# CITY OF PORTLAND BUILDING PERMIT

Job ID: 2012-03-3500-SOB

has permission to Build a new 8'x 9'1" front porch and a 14' handicap ramp at the existing double door entry provided that the person or persons, firm or corporation accepting this permit shall comply with all of the provisions of the Statues of Maine and of the Ordinances of the City of Portland regulating the construction, maintenance and use of the buildings and structures, and of the application on file in the department.

CHRIST CHURCH PORCH SECTION A

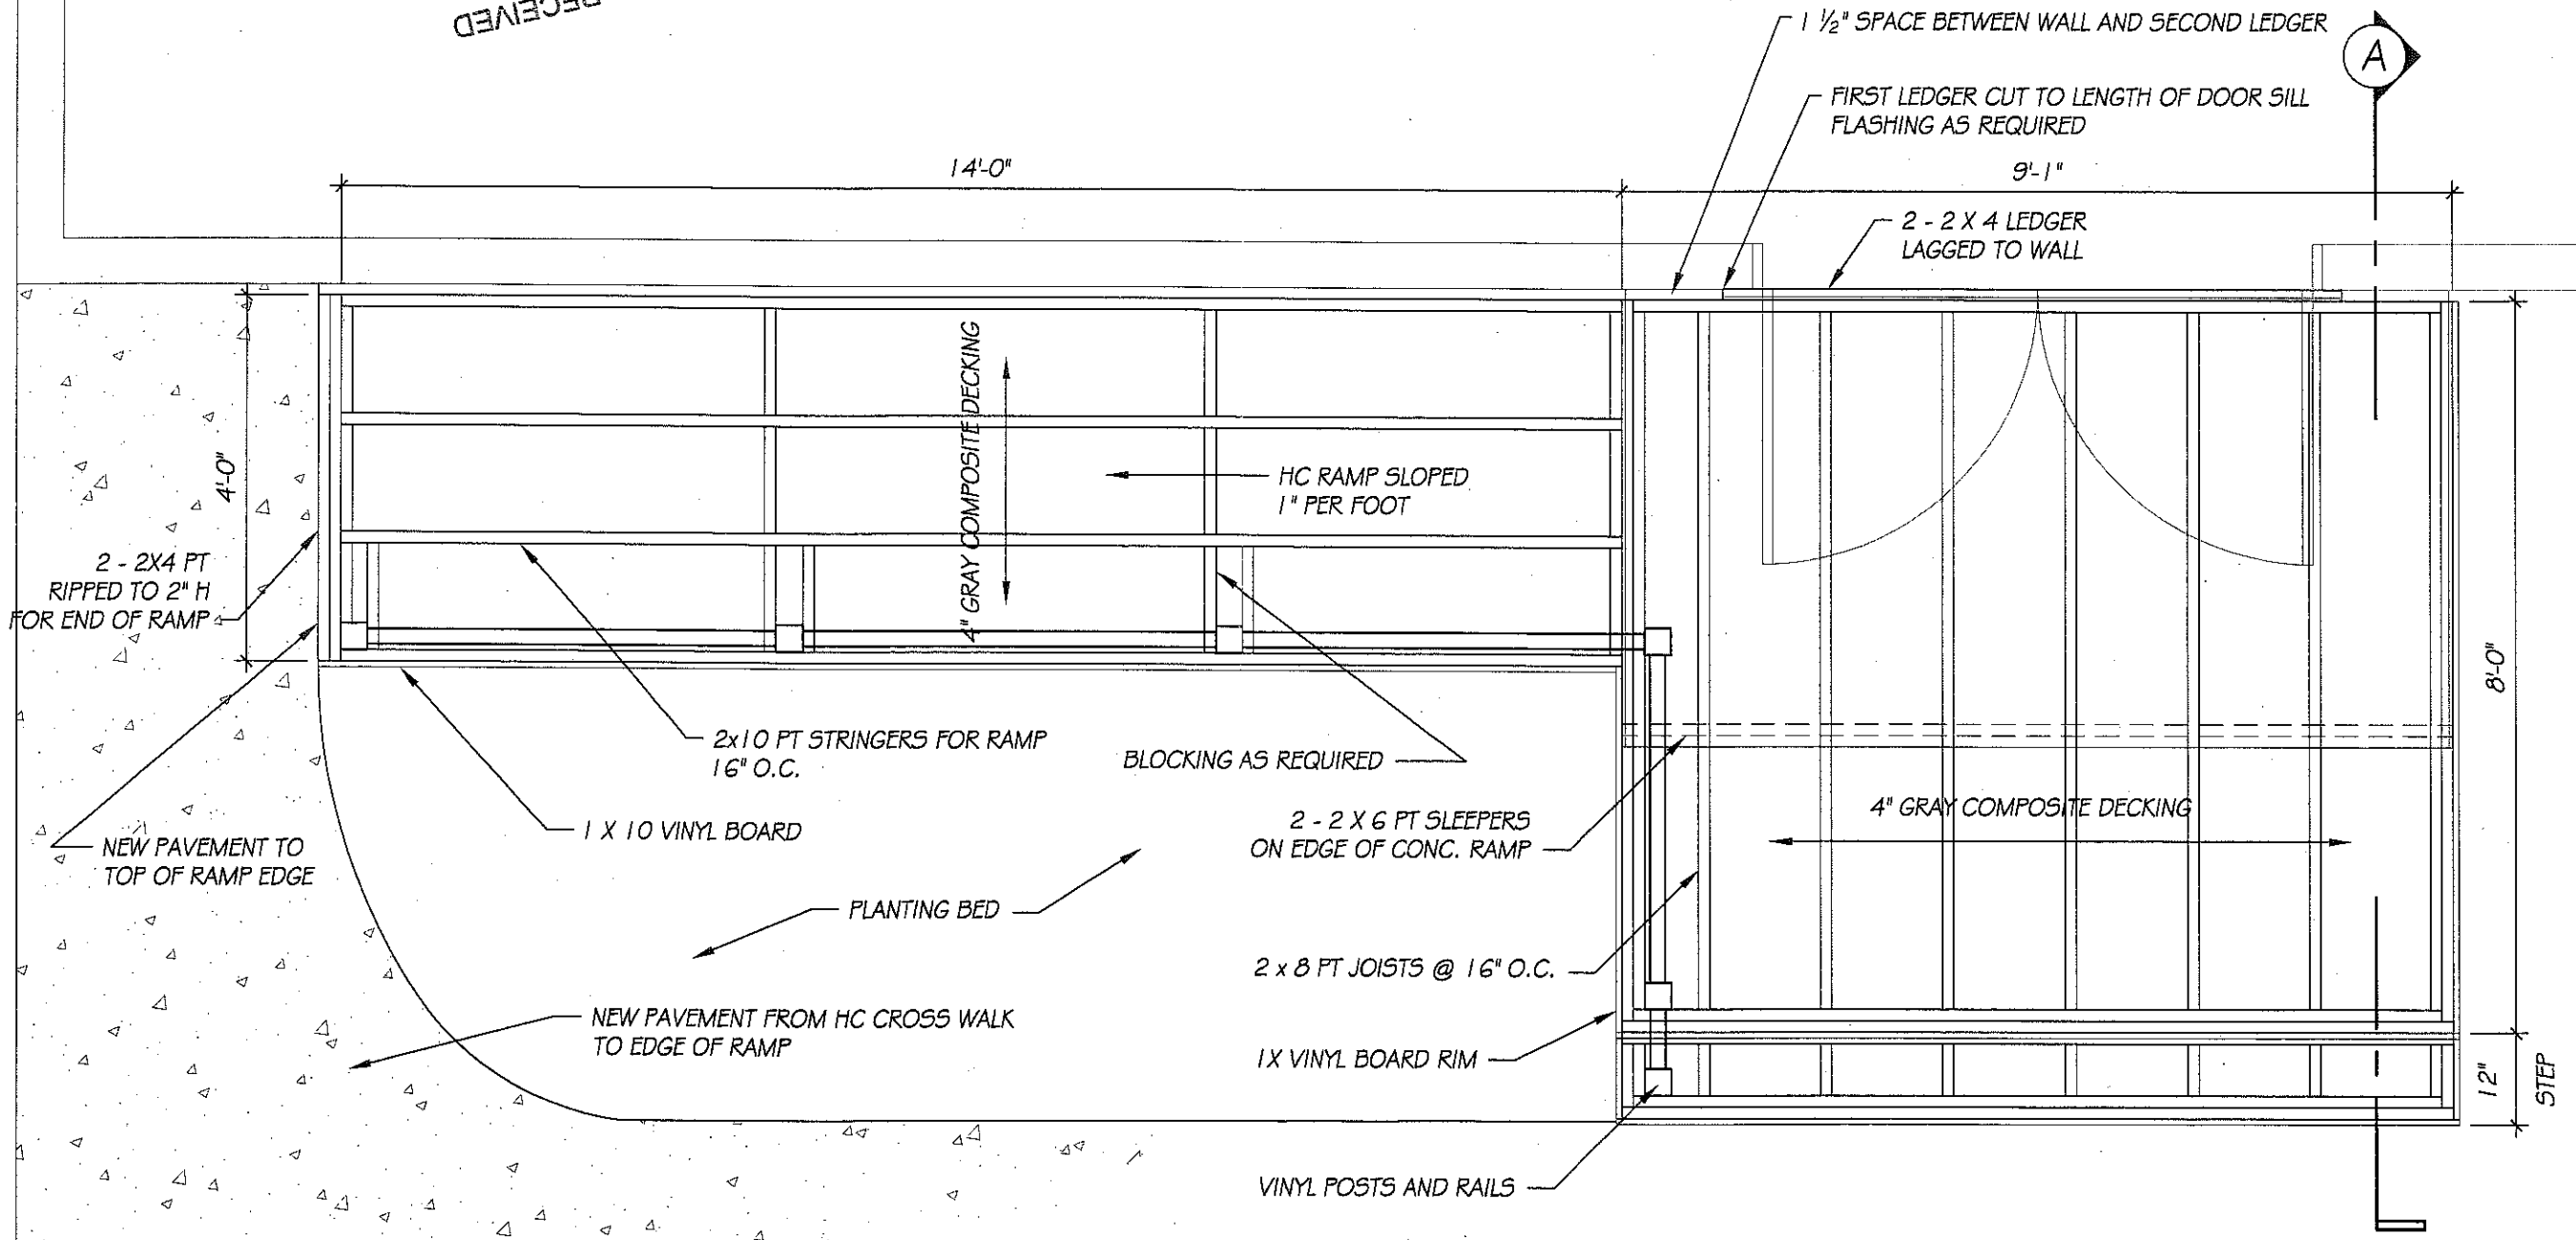
1. All construction shall comply with City Code Chapter 10.
2. Risers are only permitted to slope under the tread at an angle not to exceed 30 degrees from vertical and provided the nosing does not exceed 1 ½ inch.
3. Handrails shall be provided on both sides of the stair and ramp. Handrails shall be in accordance with NFPA 101:7.2.2.4.
4. Guards complying with NFPA 101:7.2.2.4.5 for stair, ramps and landings exceeding 30 inches above the adjacent ground or surface.
5. The ramp shall not exceed 30 inches in height and a slope of 1 in 12. It shall have a minimum clear width of 44 inches.

*Per Sherri W.  
NO nosing*
